**Addendum No. 1**

RE: Contract # C203923  
WBS # 2017CPT.03.06.10101 Etc.  
STATE FUNDED

**Brunswick County**

1 Section of US-74/US-76, 2 Sections Of NC-179 and 41  
Sections of Secondary Roads

TYPICAL SECTION NO. 2
 MAP NO. 2 – US 74 /76 WB
 BRIDGE NO. 5
 MP 10.994 – MP 11.008

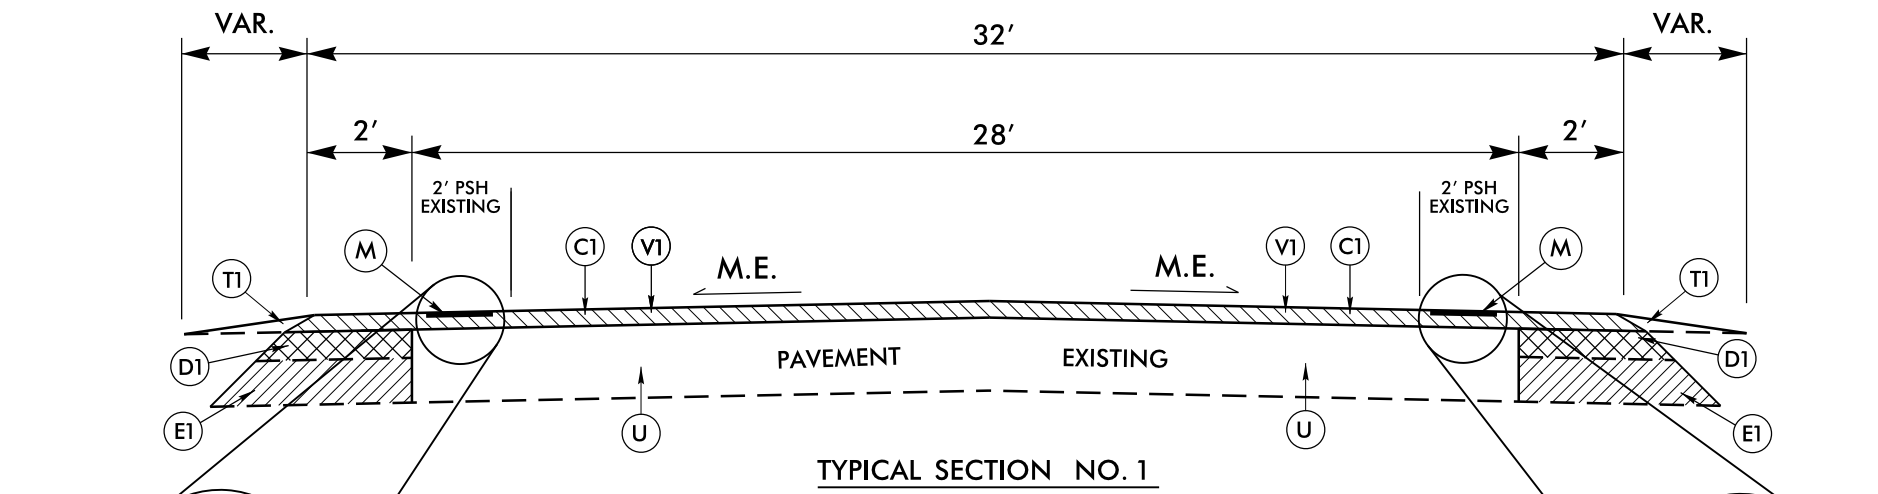
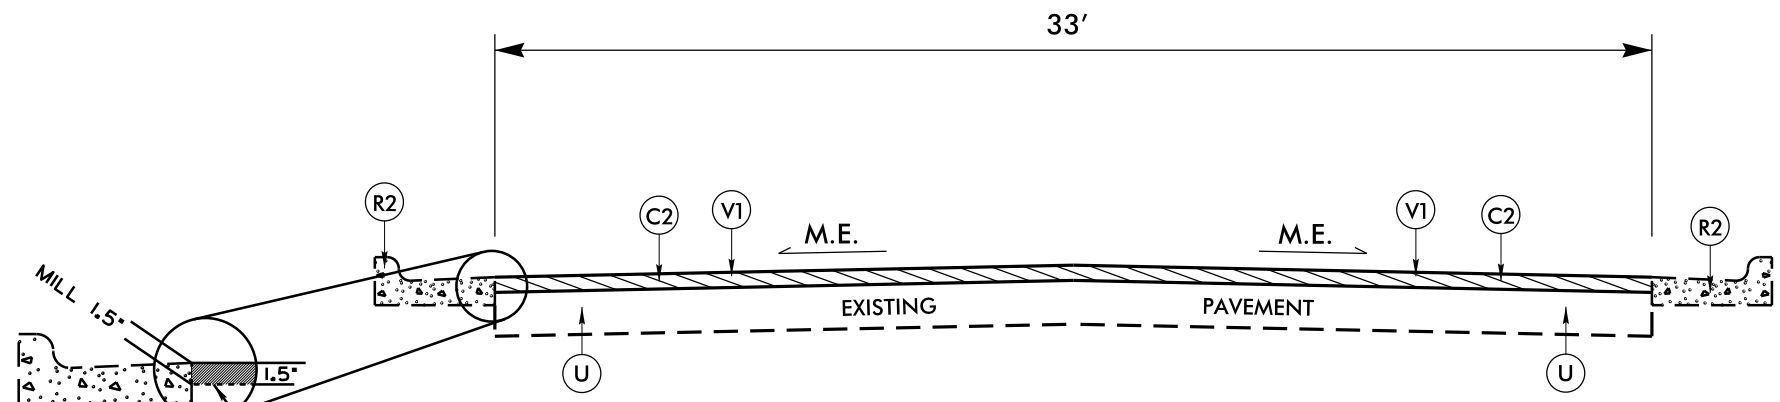
| Sheet No. | Revisions                                                                            |
|-----------|--------------------------------------------------------------------------------------|
| 4         | Revised the widening in Typical Section No. 1                                        |
